## PLANNING CONSULTATION RESPONSE

<b>Application No</b>	2025/0830
<b>Proposal</b>	Erection of sub-station (amended plans)
<b>Address</b>	LOCATION: 418 Carlton Road, Carlton, Barnsley, S71 3HX
<b>Date of Consultation Reply</b>	09/01/2026
<b>Consultee</b>	SYMAS

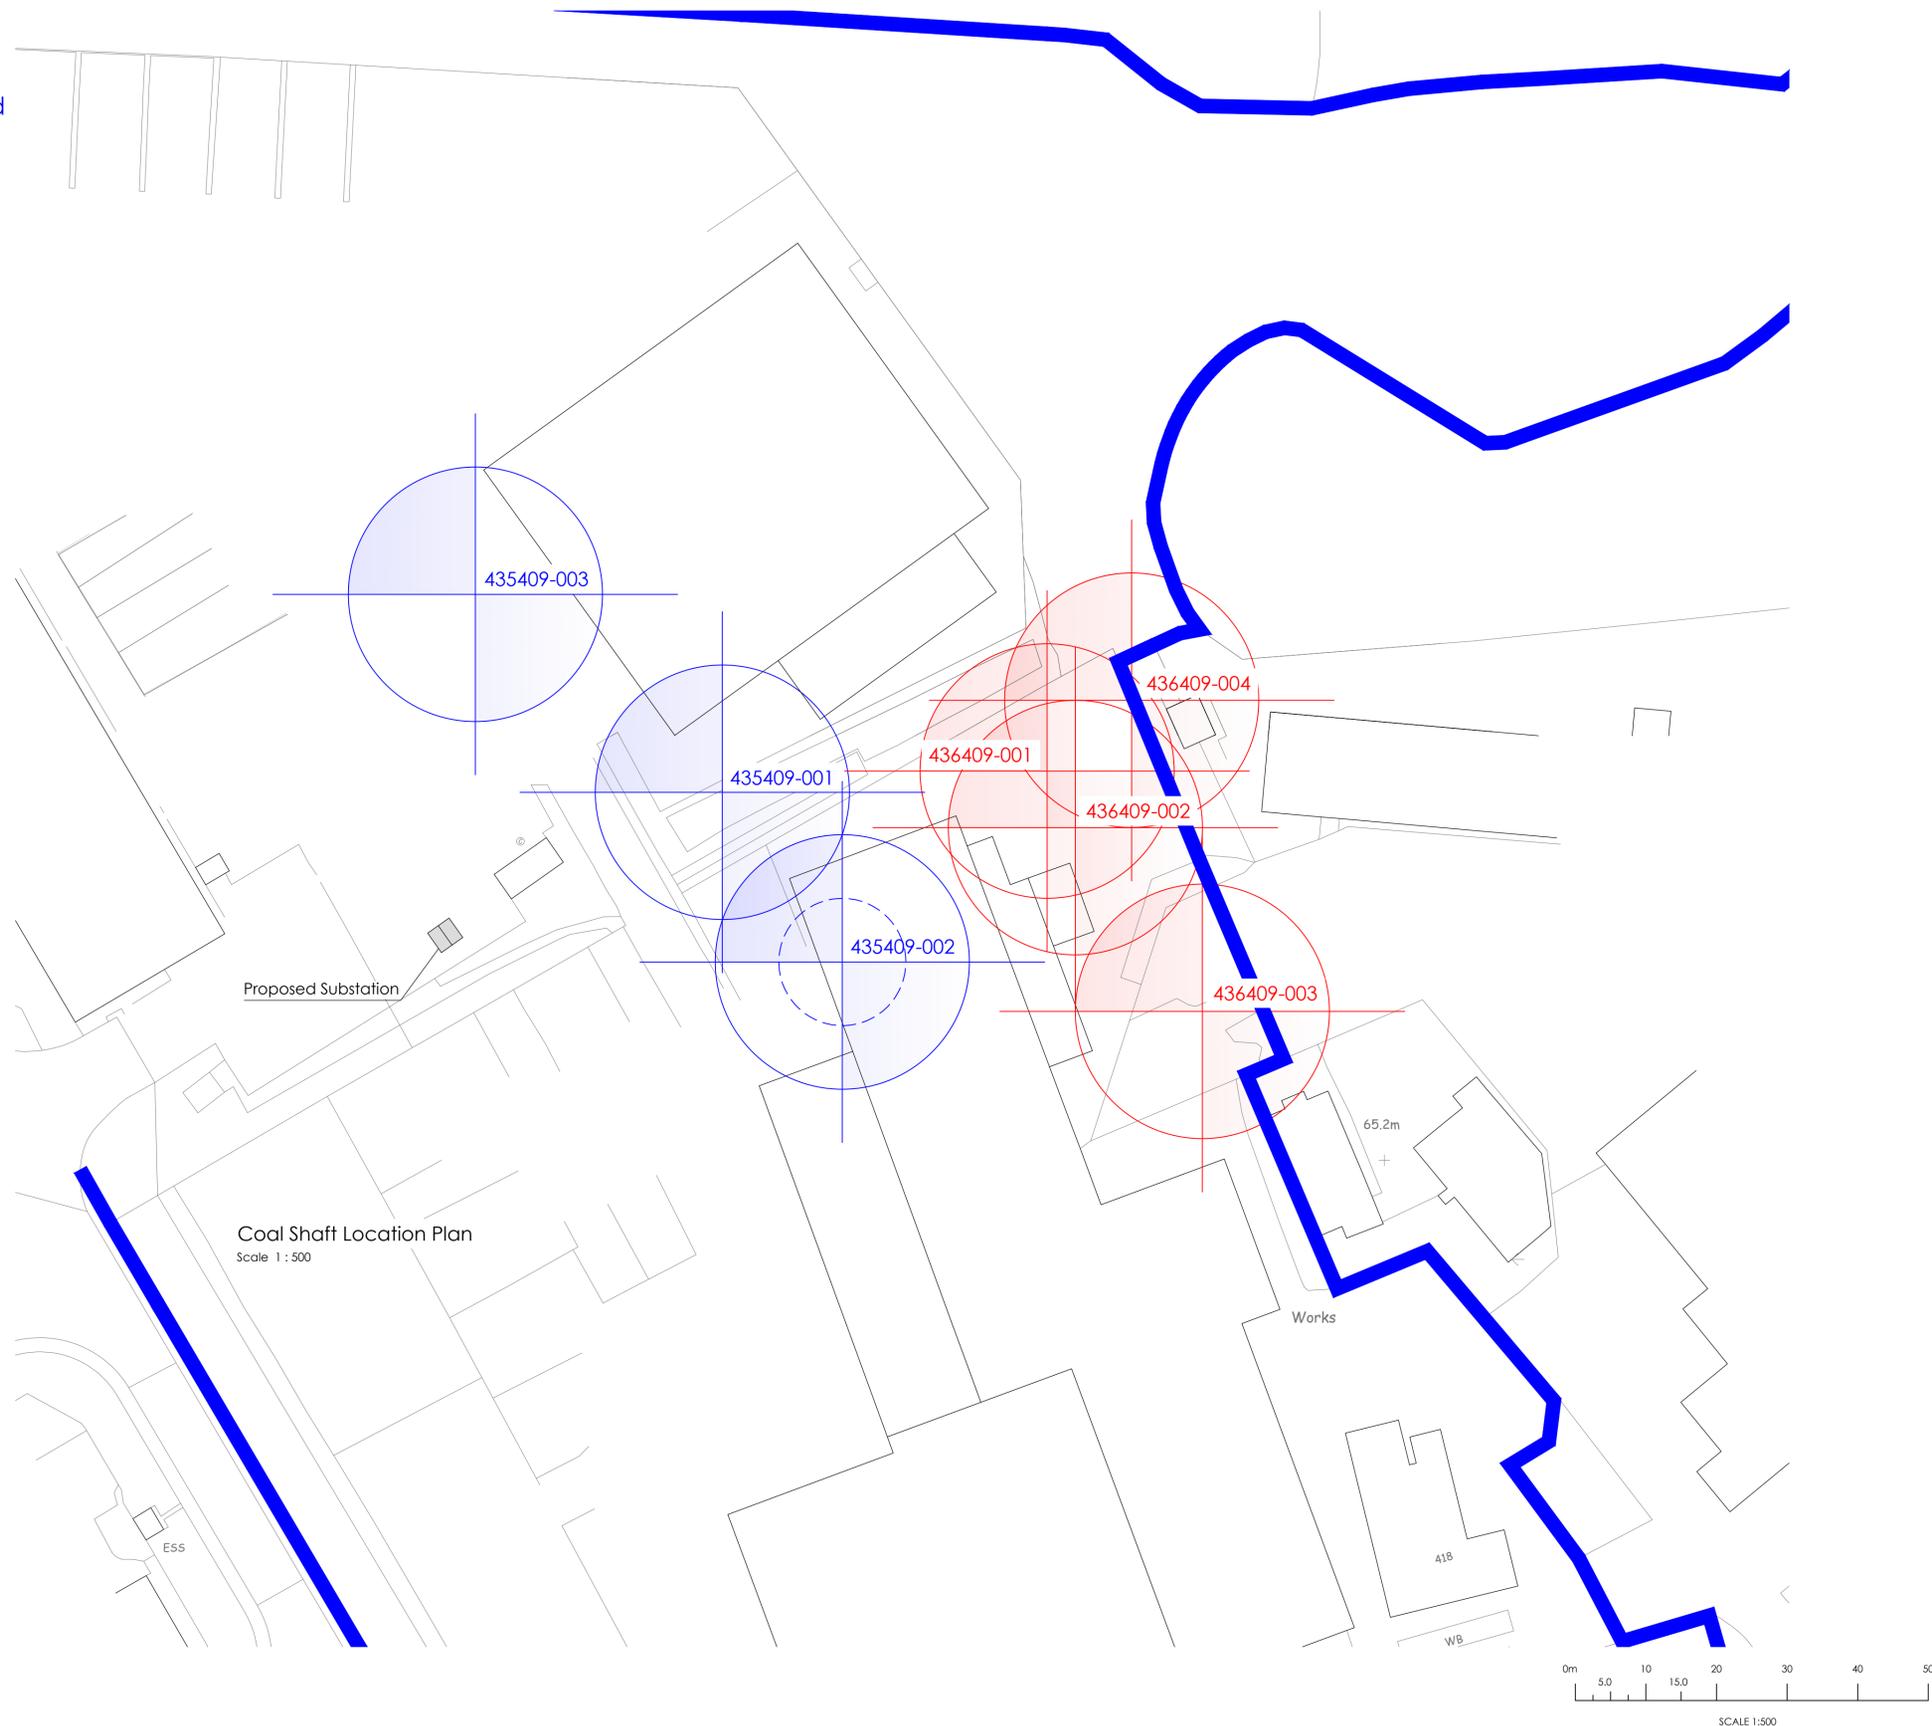
The amended substation position is not located within a Mining Remediation Authority High Risk Planning Referral area.

The applicant amended the location in light of concerns regarding the previous planned position being in proximity to disused mineshafts and associated standoff zones. The substation location is now located clear of the referral area/shaft standoffs.
